CITY OF PORTLAND, MAINE
HISTORIC PRESERVATION BOARD

July 22, 2005

Re: Exterior and Site Alterations – 110 Winter Street

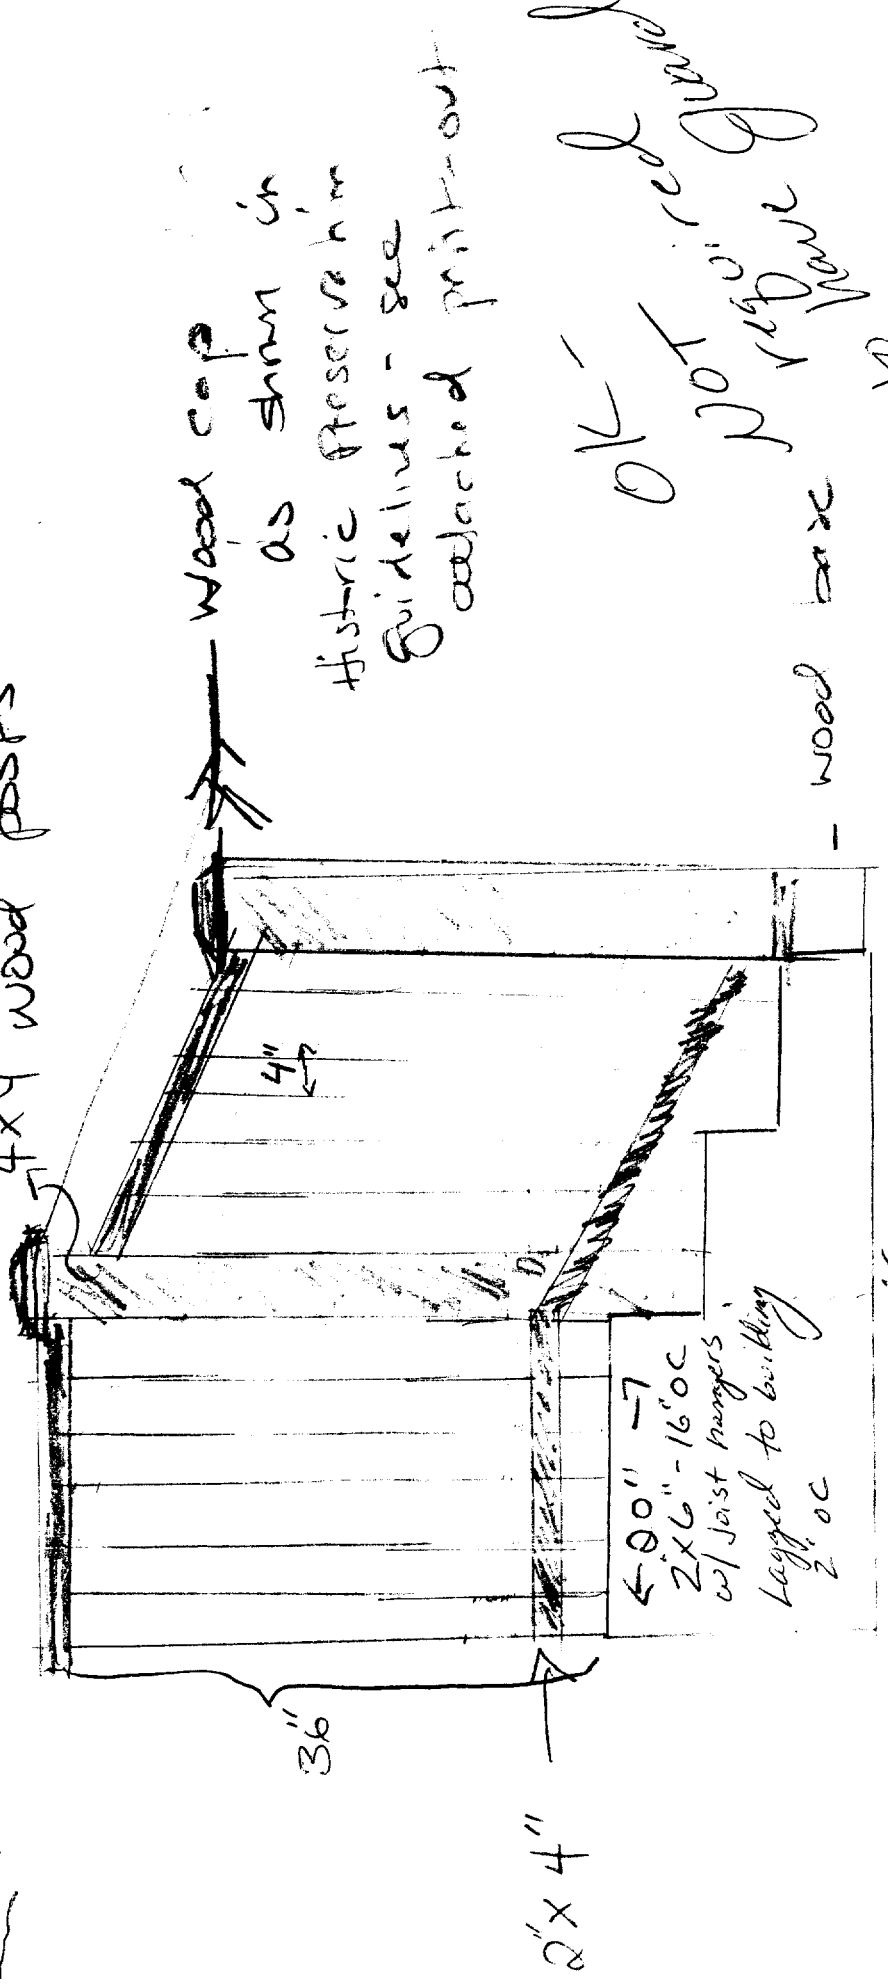
- The new door surround shall replicate the Greek Revival door surround at 108 Winter Street.
- Exterior trim around the new dummy window above the front door shall replicate that of the other windows on the main house.
- The two proposed replacement windows on the first floor of the rear ell (south elevation), shall be aligned and framed to match the windows directly above them.
- Note that the current roof deck balustrade projects beyond the wall plane and its leading edge projects above the gable roof. The replacement balustrade should be set back a sufficient distance that it is recessed from the wall plane and its leading edge does not project above the gable roof.
